Application Ref:	3/2026/0296			 Ribble Valley Borough Council <small>www.ribblevalley.gov.uk</small>				
Date Inspected:	28/04/2026	Site Notice:	28/04/2026					
Officer:	MC							
DELEGATED ITEM FILE REPORT:					REFUSAL

Development Description:	Prior notification for proposed installation of a 15m telegraph pole supporting 3no. antennas, 2x 0.3m dishes, 3no. equipment cabinets and ancillary development thereto including 1.2m fence with 3m double access gates and underground cabling.
Site Address/Location:	Land northeast of Cold Coates Farm, Collins Hill Lane, Chipping, PR3 2WQ

Title: 150 PROPOSED SITE PLAN

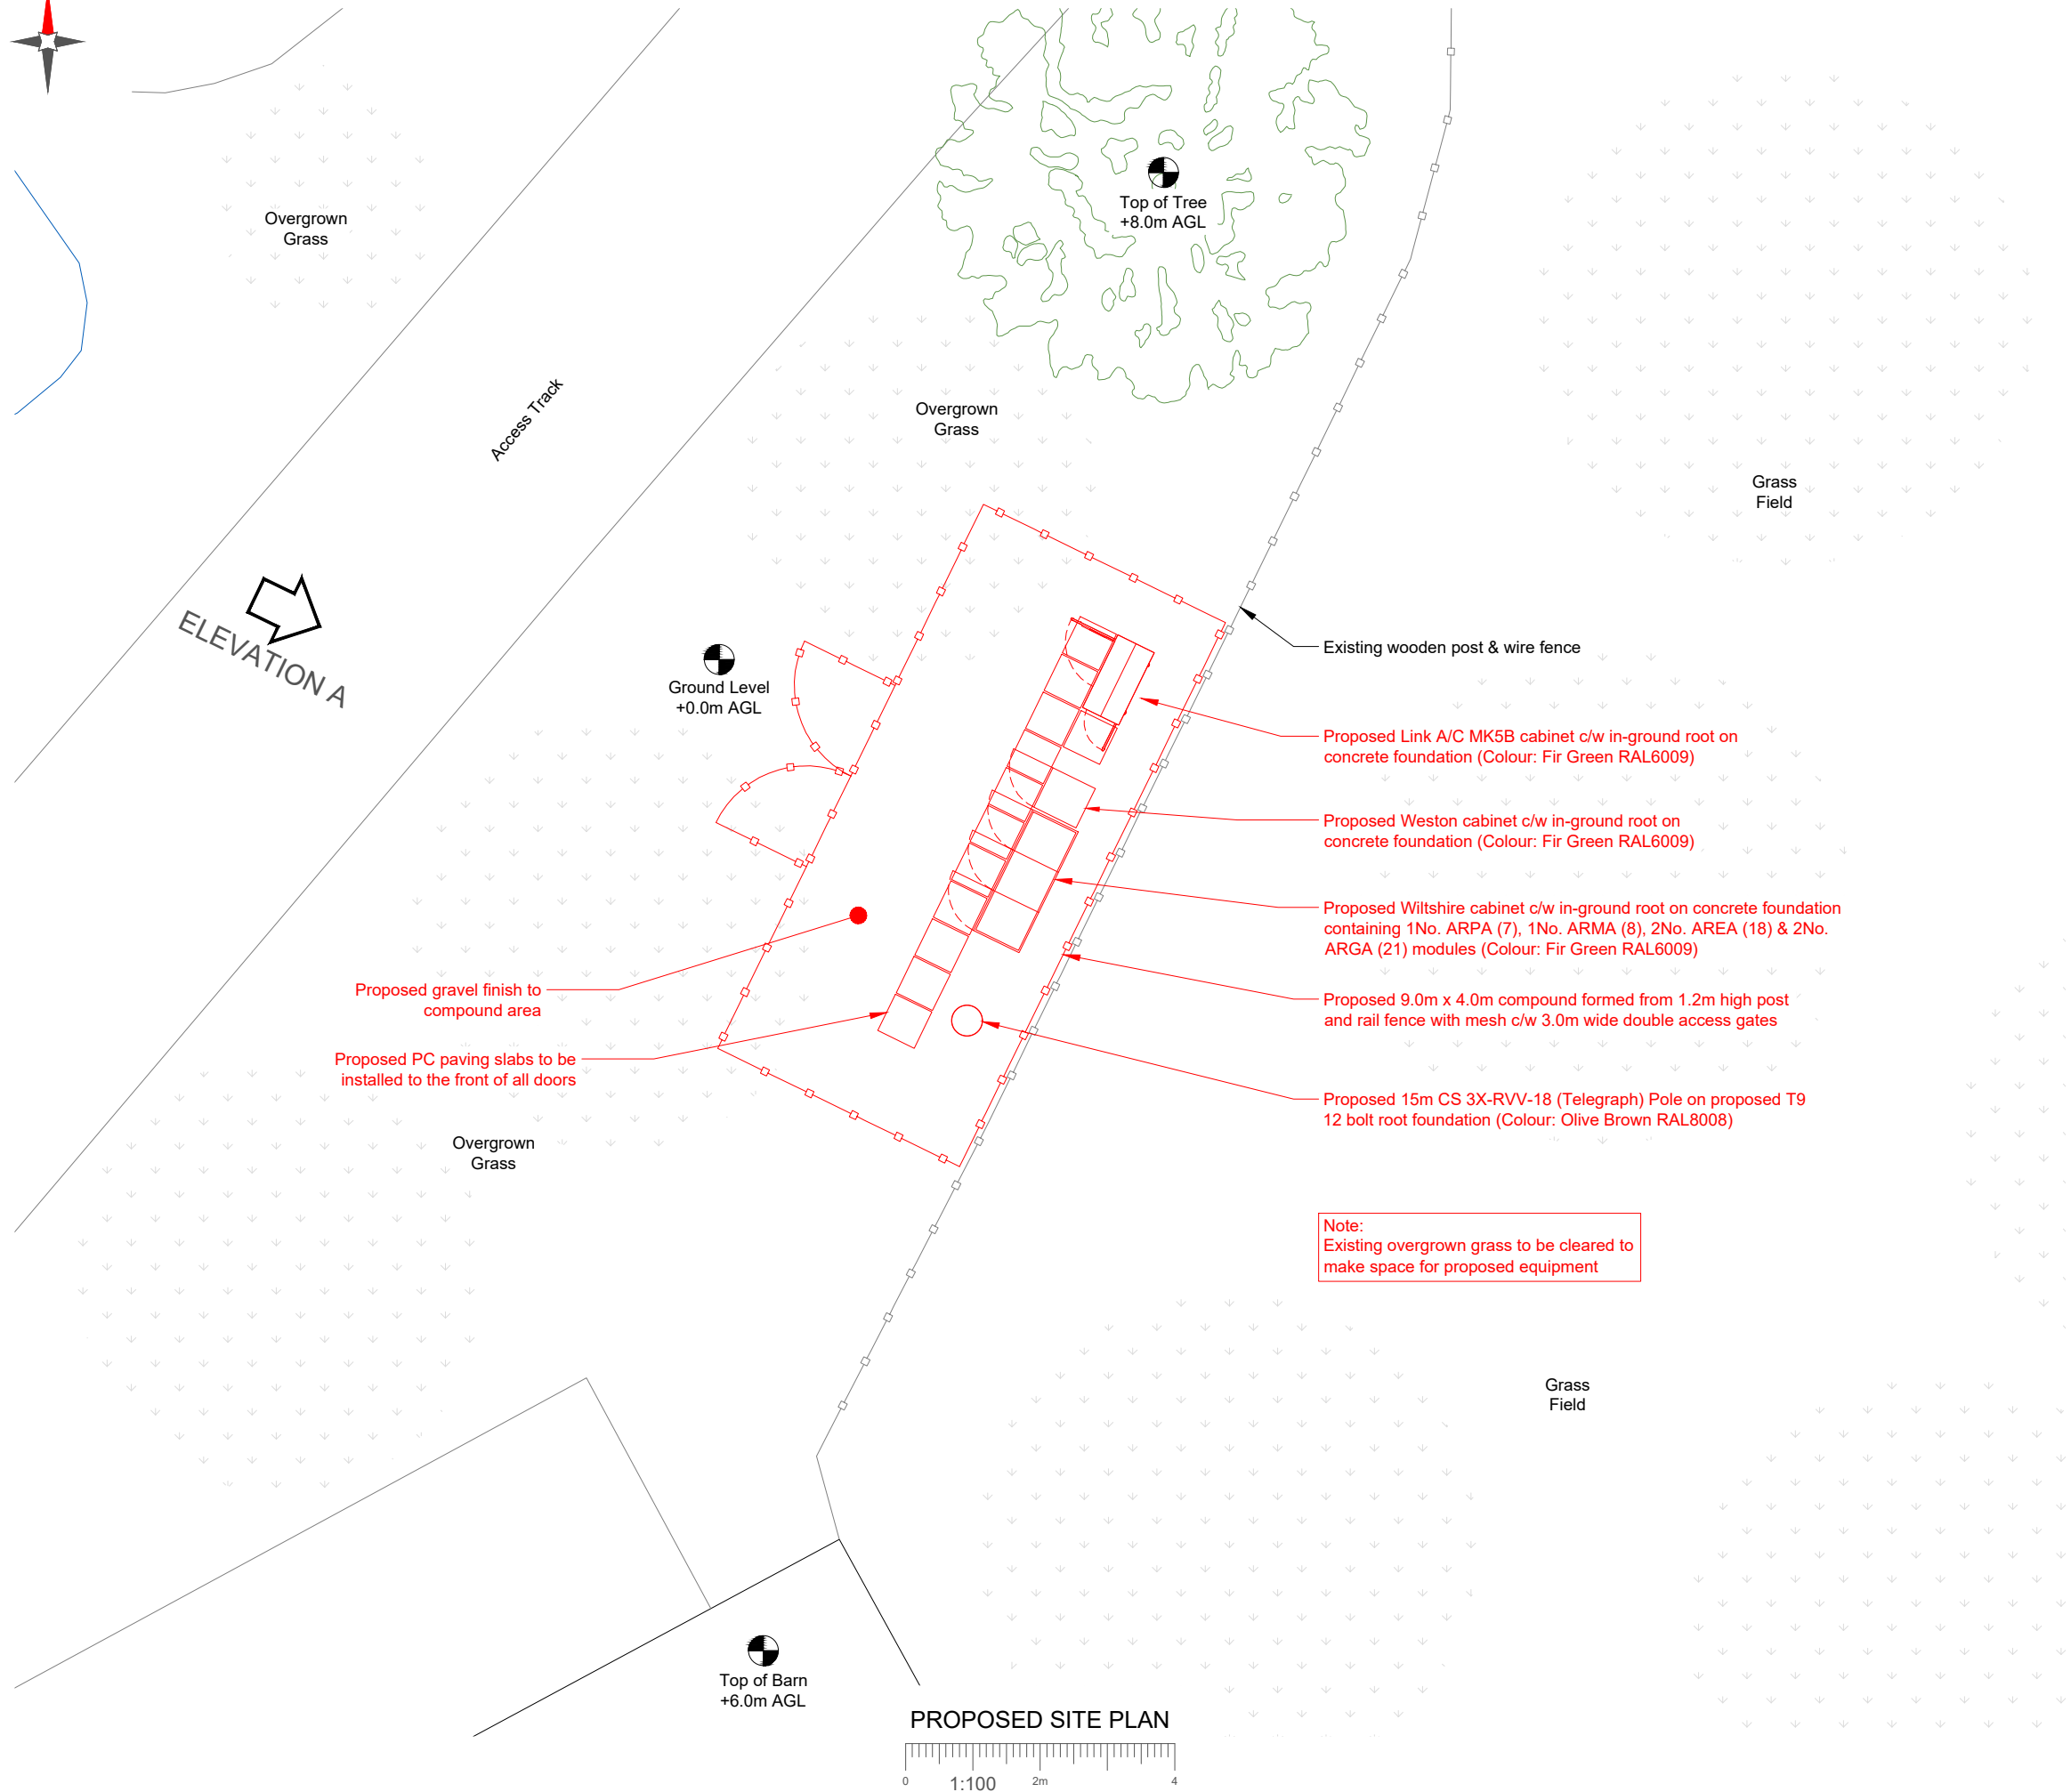
The application is supported by a photomontage which identifies a number of viewpoints that the proposed mast would be visible from within the vicinity of the site. The Council raise concerns with regards to the siting of the proposed mast and ancillary equipment and the harm that to the landscape and character of the Forest of Bowland National Landscape.

Notwithstanding the comments within the supporting statement that the site is screened by existing buildings at Cold Coates Farm, it is evident that the mast would be in a highly prominent position within the National Landscape. In particular, the mast would be visible from View Points 1, 2 and 4 and also from the Public Right of Way which runs immediately adjacent to the site. Whilst some mitigation measures have been put forwards to minimise the visual impact, including using an Olive Brown colour for the mast and Fir green for the associated equipment in attempt to lessen the visual impact, this would not fully mitigate the harm that would arise to views of the surrounding hills which positively contribute to the scenic beauty of the National Landscape. Whilst some views of the mast would be partially obscured by the existing buildings at Cold Coates Farm, the site remains fairly open within the landscape. It should also be noted that the existing mast is sited towards the top of Longridge Fell and is not viewed in the same context as the current proposed amended location, which would be sited in the foreground of scenic hill views within the National Landscape, constituting an incongruous addition.

Title: **250 PROPOSED SITE ELEVATION**

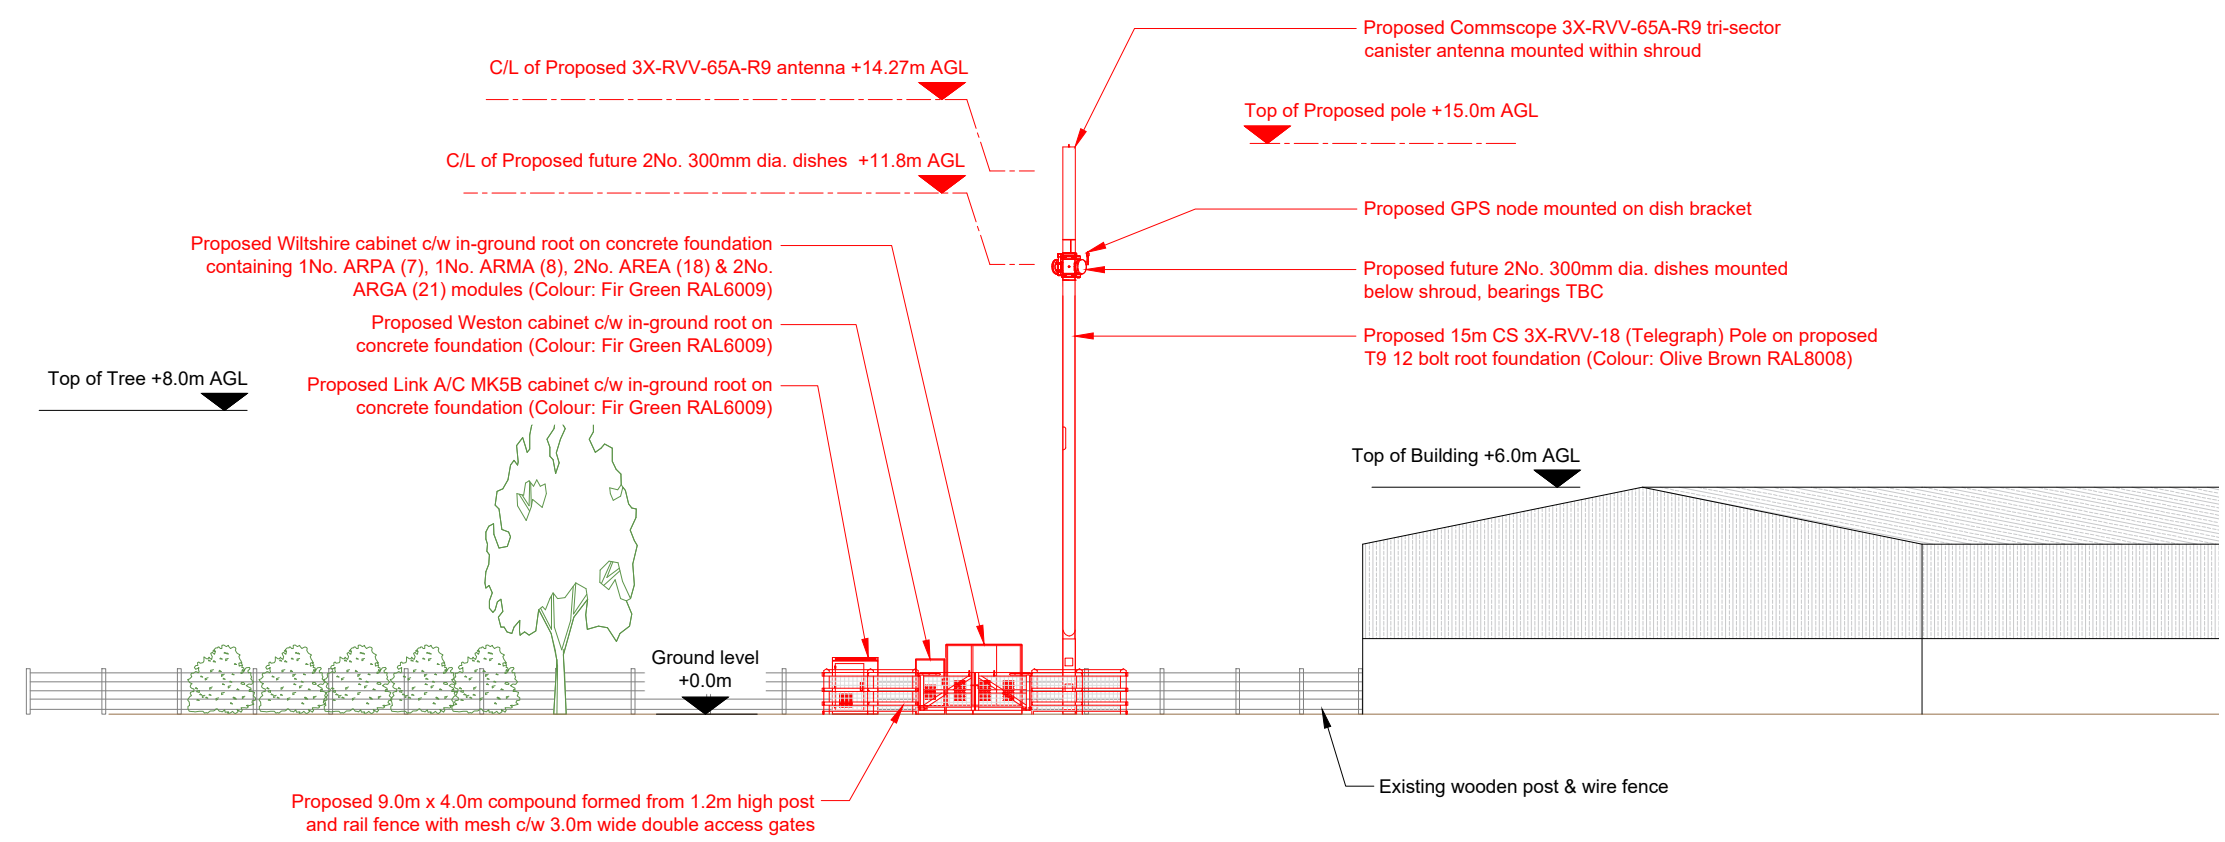
The proposal relates to the installation of a new 15m high mast and ancillary equipment. The site is in a highly visible location, within a Public Footpath running immediately adjacent to the mast and the site is viewed in relation to the distance hills within the Forest of Bowland National Landscape.

As such, the proposal would fail to accord with Key Statement EN2, and Policies DMG1 and DMG2 of the Ribble Valley Core Strategy and the aims and objectives of Para.189 of the National Planning Policy Framework and Prior Approval is required with regards to siting and appearance.
